From: [Brenda Larsen](#)
To: [Jeff Watson](#)
Subject: RE: BL-10-00037 Hanson
Date: Tuesday, November 09, 2010 11:43:06 AM

Re: Hanson (BL-10-00037)

Proposed

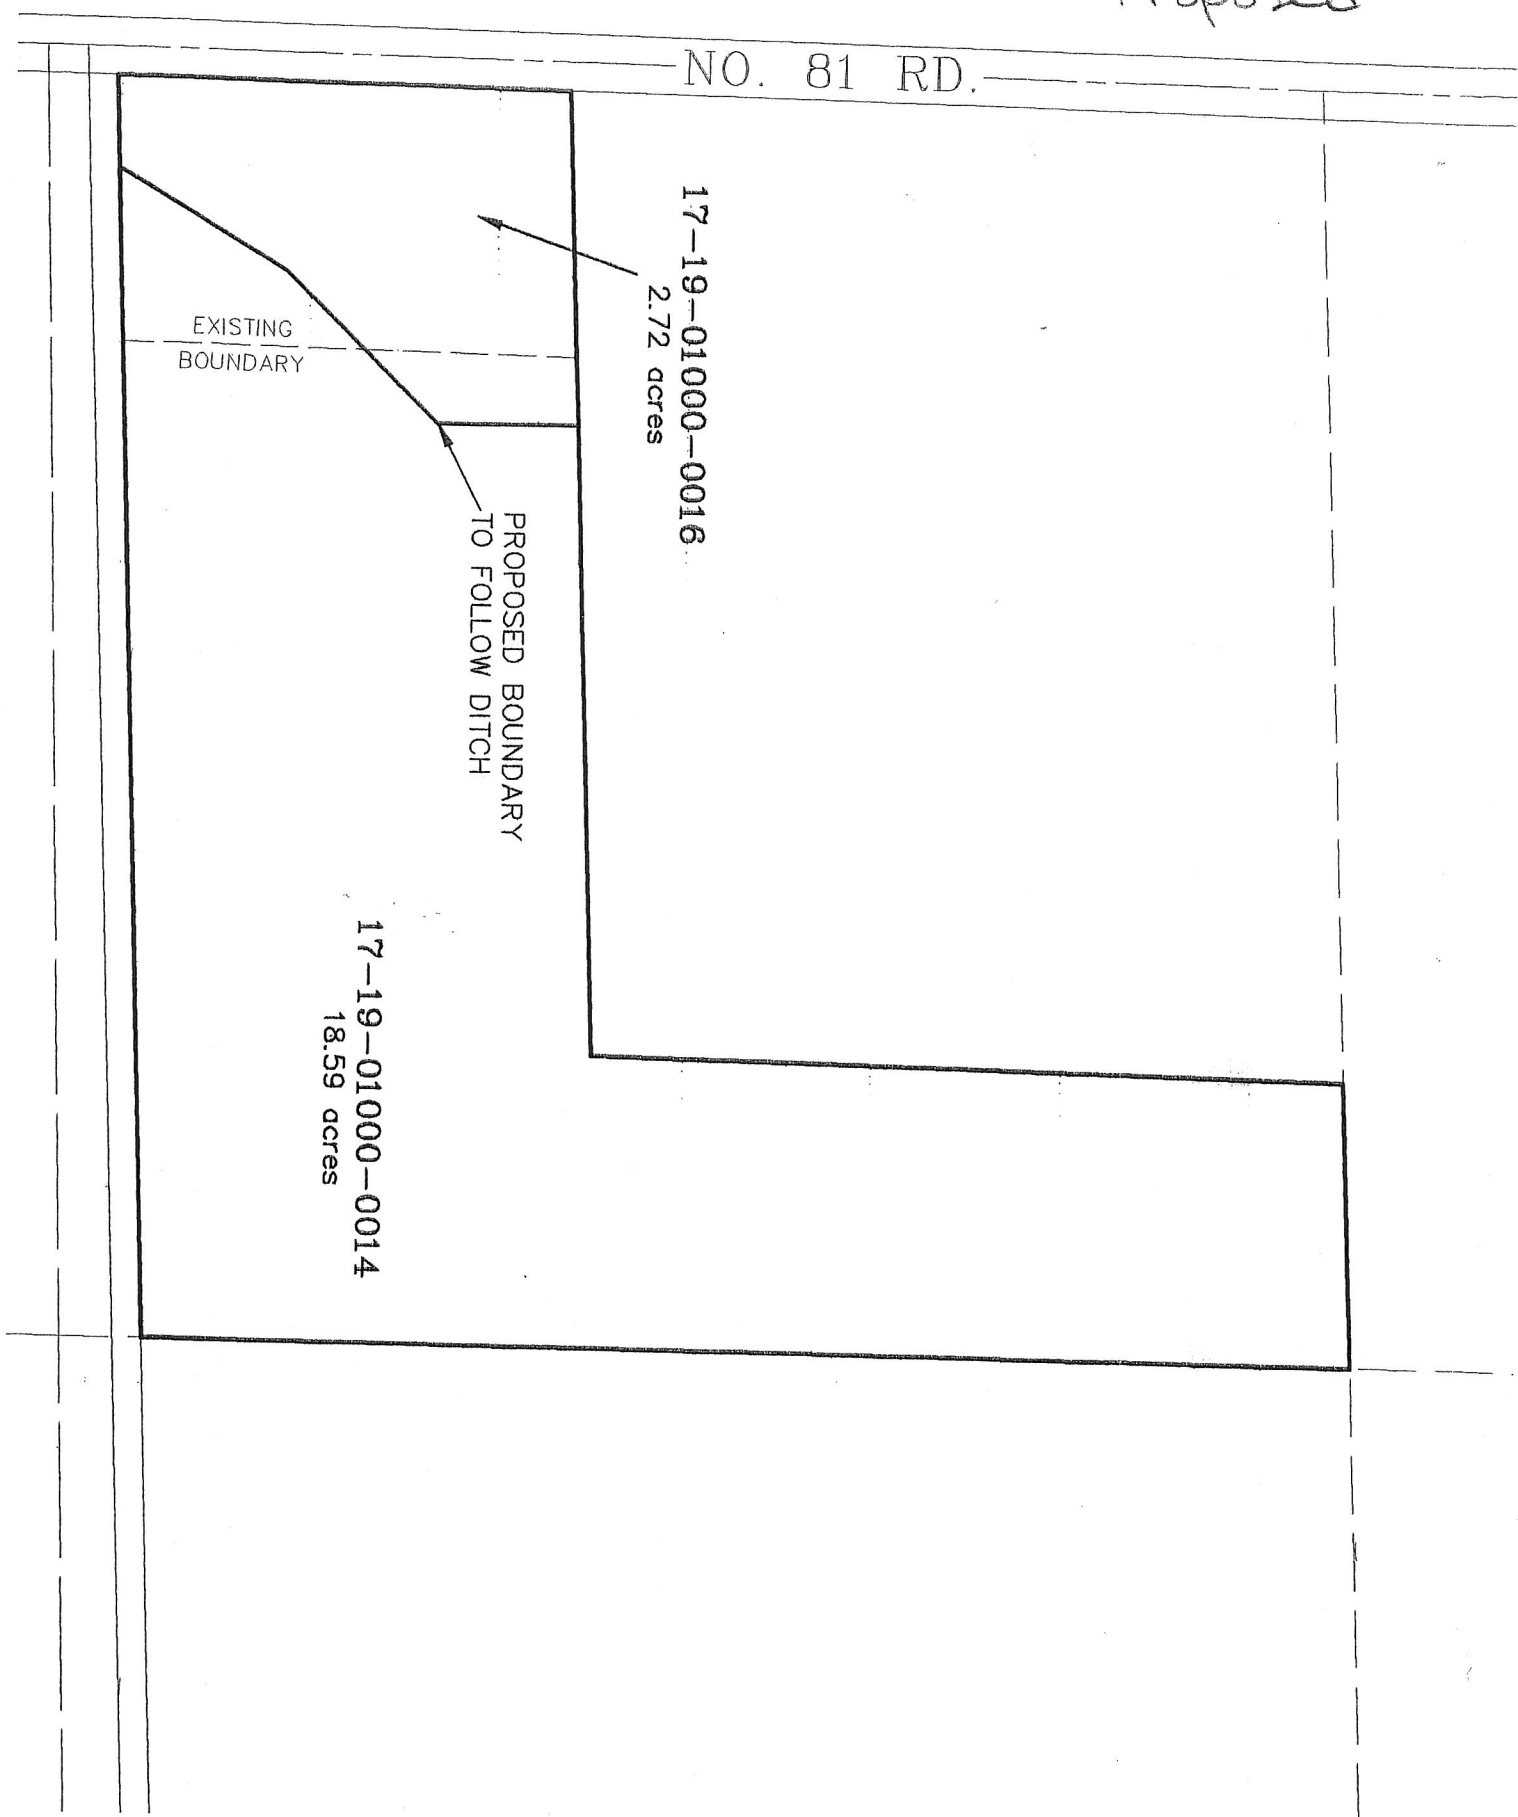
- All future development must comply with the International Fire Code.
- Ensure that boundary line adjustments do not infringe upon existing structures, to include propane tanks, etc.
- Creation of future lots will necessitate fire apparatus access requirements.
